RE: BP#2016-01901 49 Hancock Street

Thank you for taking time yesterday to go over your comments.
As per our conversation, I have revised, added comments and details.

# EAST ELEVATION

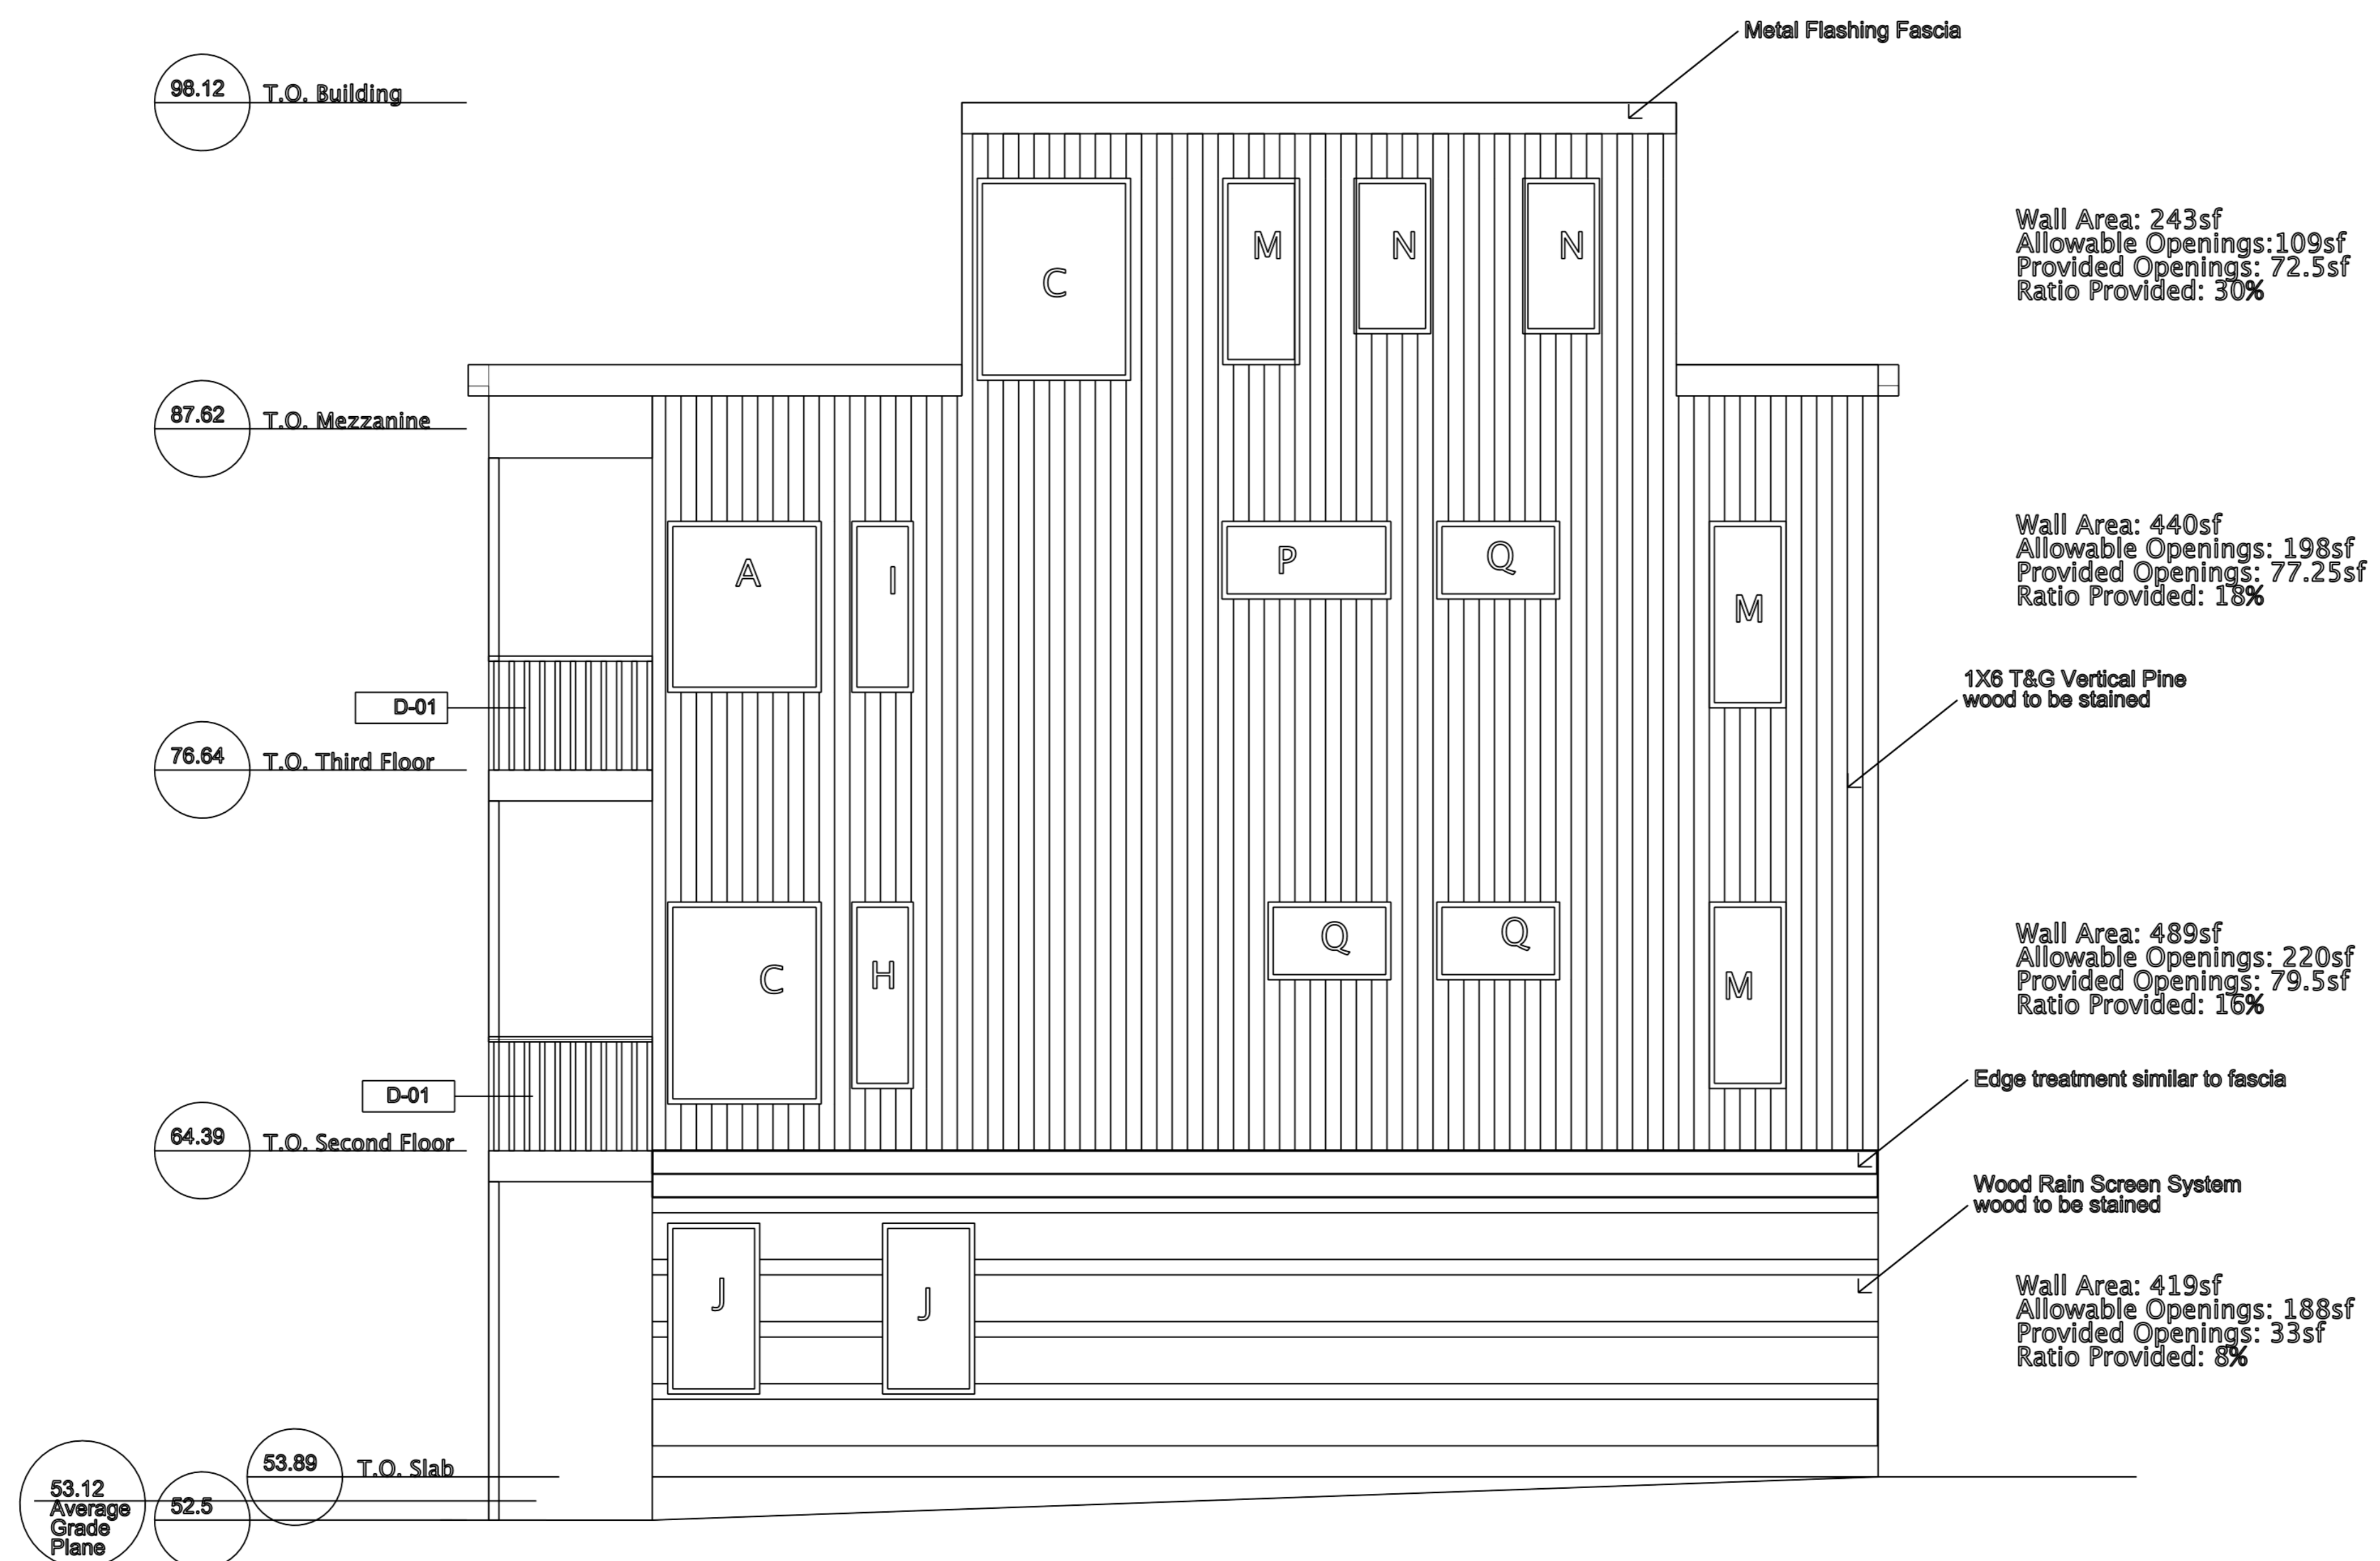
6. **A2.2** Windows within 5' to 10' of the fire distance are reduced in sizes to meet 25% allowance.
7. **A2.3** Note added for the fire rated door. (please also see the manufacture's cut sheet for the door)

DRAWN BY **LRC**
SHEET TITLE **COVER**

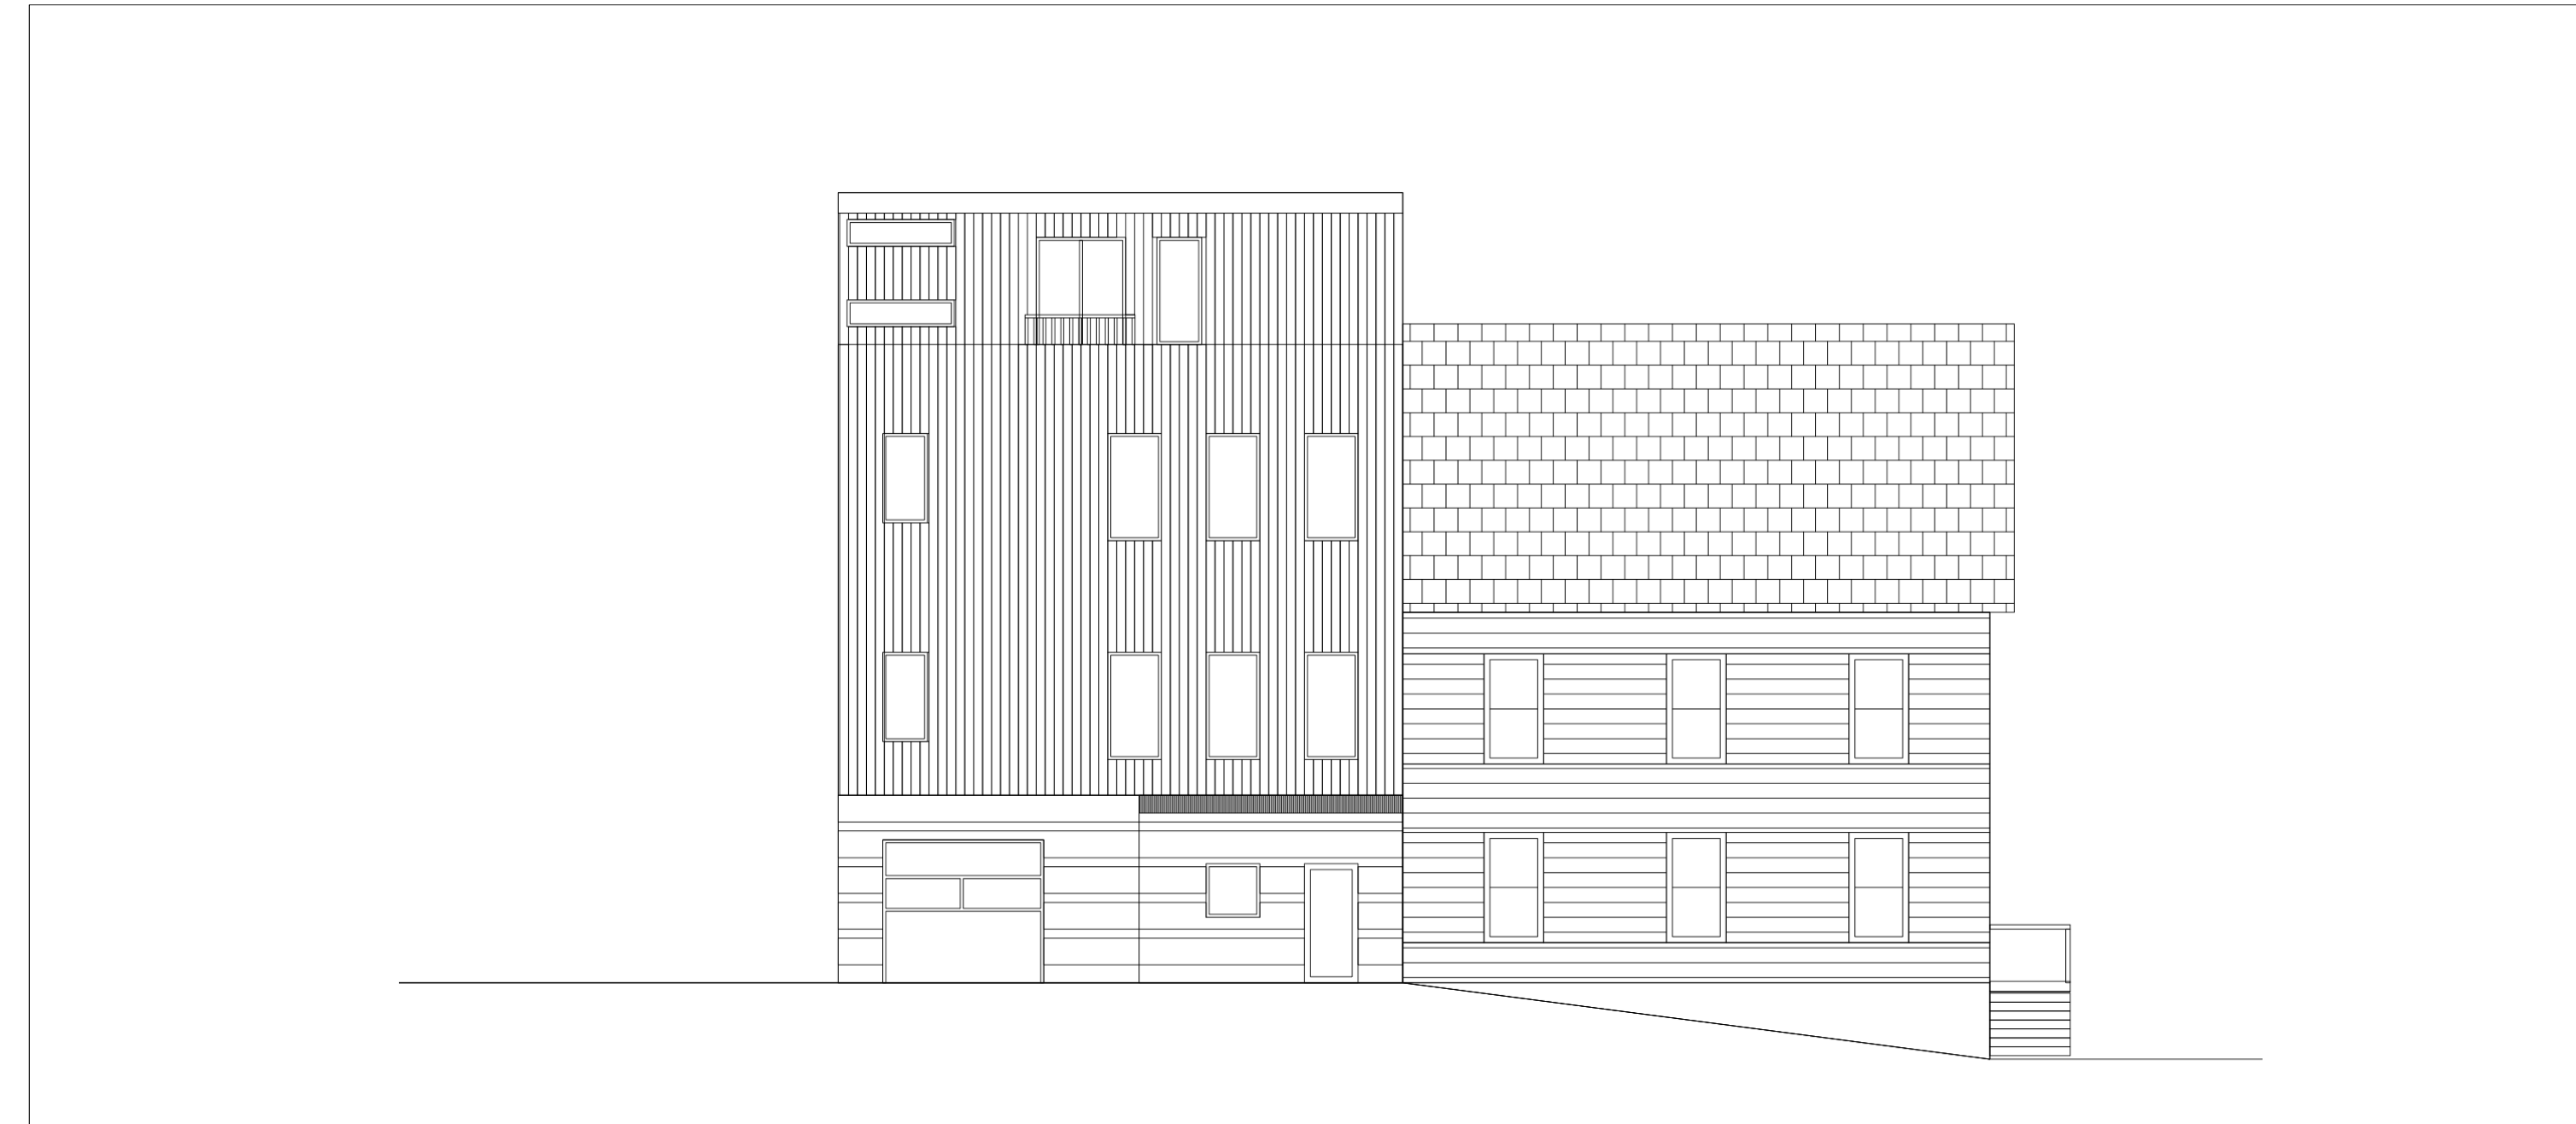
11. **Cov 1.0** Updated per new occupancies (R-2, S-1, S-2). Added parapet and fire wall notes.
